**OXFORDSHIRE COUNTY COUNCIL'S RESPONSE TO CONSULTATION ON THE
FOLLOWING DEVELOPMENT PROPOSAL**

Application no: 14/01478/REM

Proposal: Construction of a road with associated infrastructure within the Heyford Park development.

Location: Heyford Park Camp Road Upper Heyford Bicester OX25 5HD

HEYF/5/850

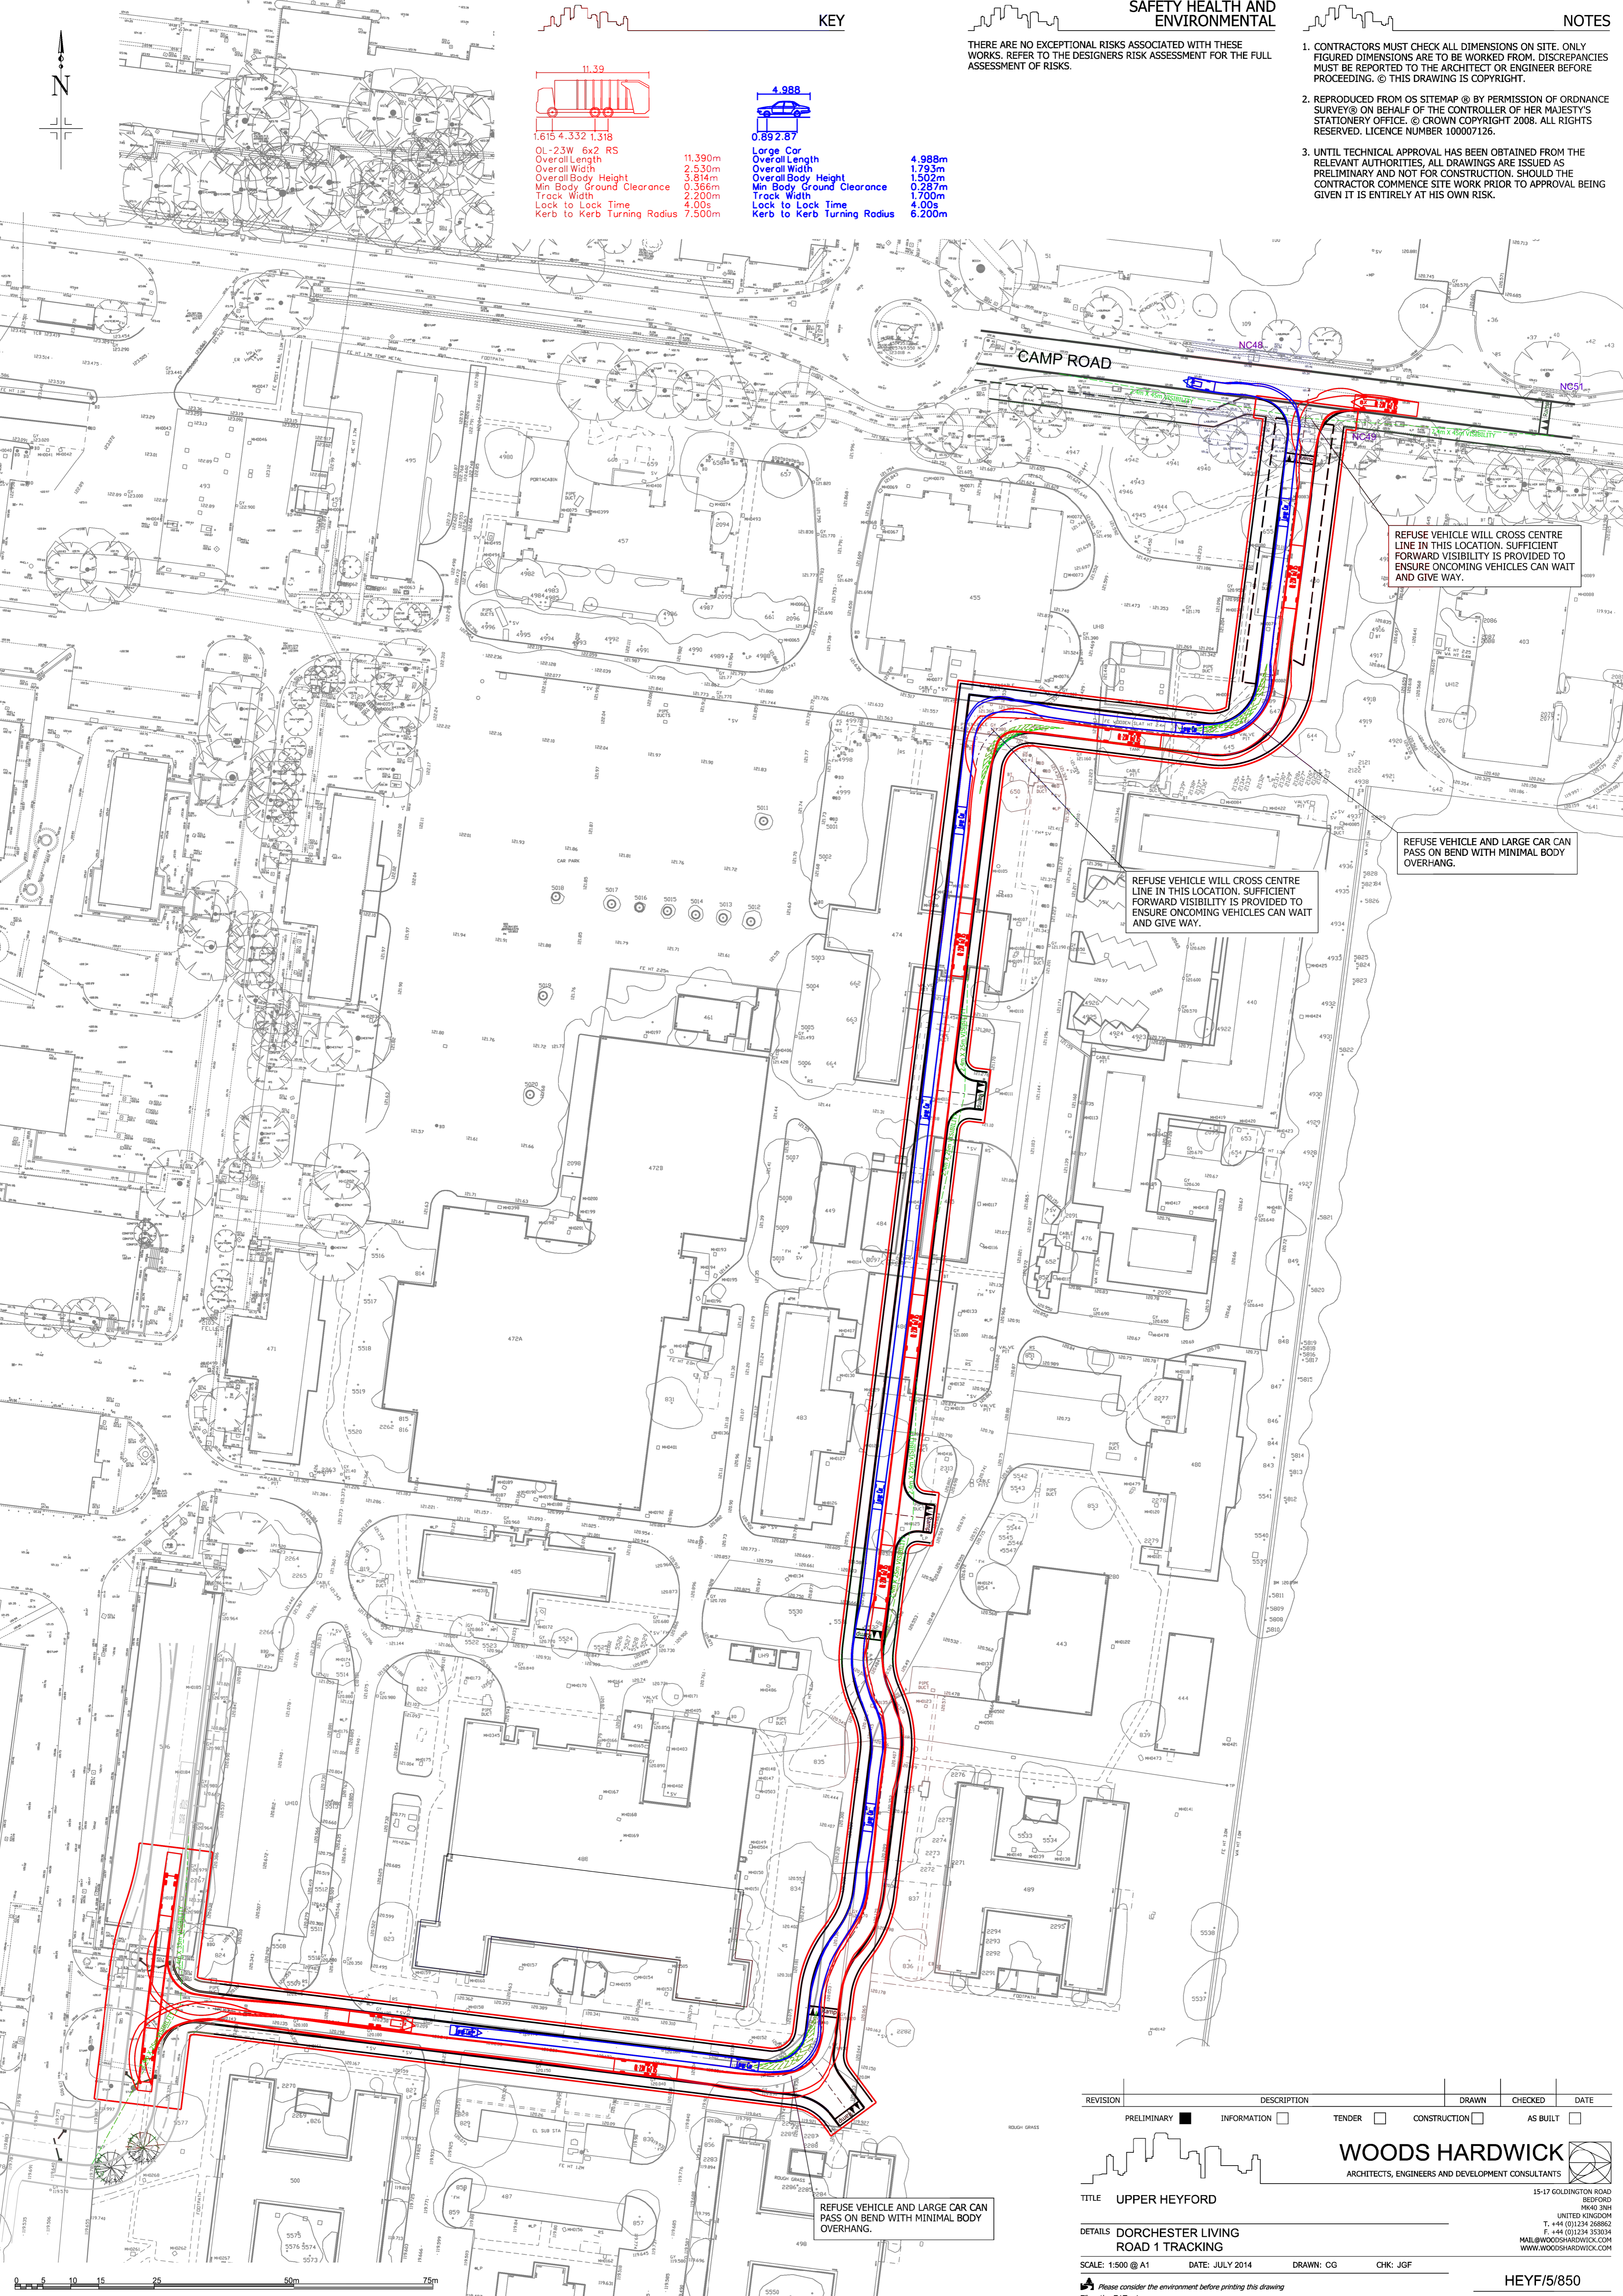
On plan No.HEYF/5/850 an 11.39m refuse vehicle is shown to cross the centre of the road in two places, and to overhang in two places. OCC do accept overhang over verge, but will not accept overhang over footways or parking bays. OCC would accept tracking for a 10.0m refuse vehicle.
